WINTEN
21 OCT 2010
PROPERTY GROUP

North Sydney Zone Substation Redevelopment

Thank you for inviting me to review the "Electric and Magnetic Fields Assessment (December 2009)" of the EA North Sydney Zone Sub-station, EMF report.

Figure 9-35 – Predicted magnetic field contribution at Level 2 of the proposed mixed use development (commercial level)

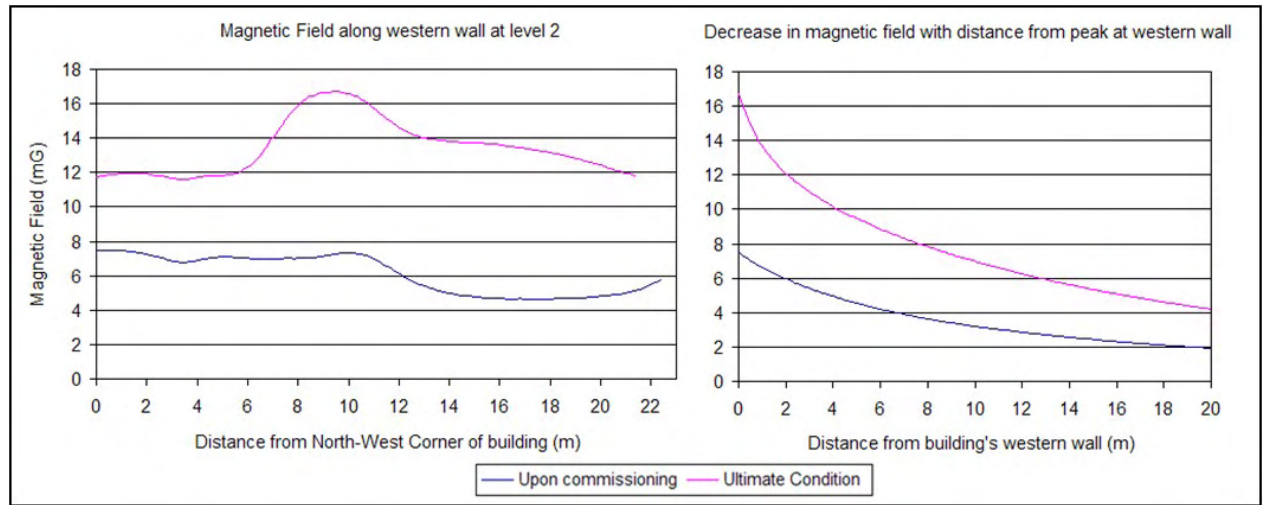
- **Figure 1, page 12**

The magnetic field levels along the eastern boundary would not be acceptable within a residential or office space, as noted above. Our client requires meaningful information as to what levels his tenants or occupiers are likely to receive at any point in the proposed development with particular emphasis on sleeping areas. We require magnetic fields at distances normal to the sub-station eastern wall at all levels of their development. Figure 2 provides some of this information. At 10 metres from the boundary reasonable fields can be achieved but what does our client do with the property closer to the boundary?

We therefore request Energy Australia adhere to their best practice of prudent avoidance and take steps to install suitable magnetic shielding and reduce the magnetic fields along the eastern boundary to no more than 4 milligauss (0.4 microtesla).
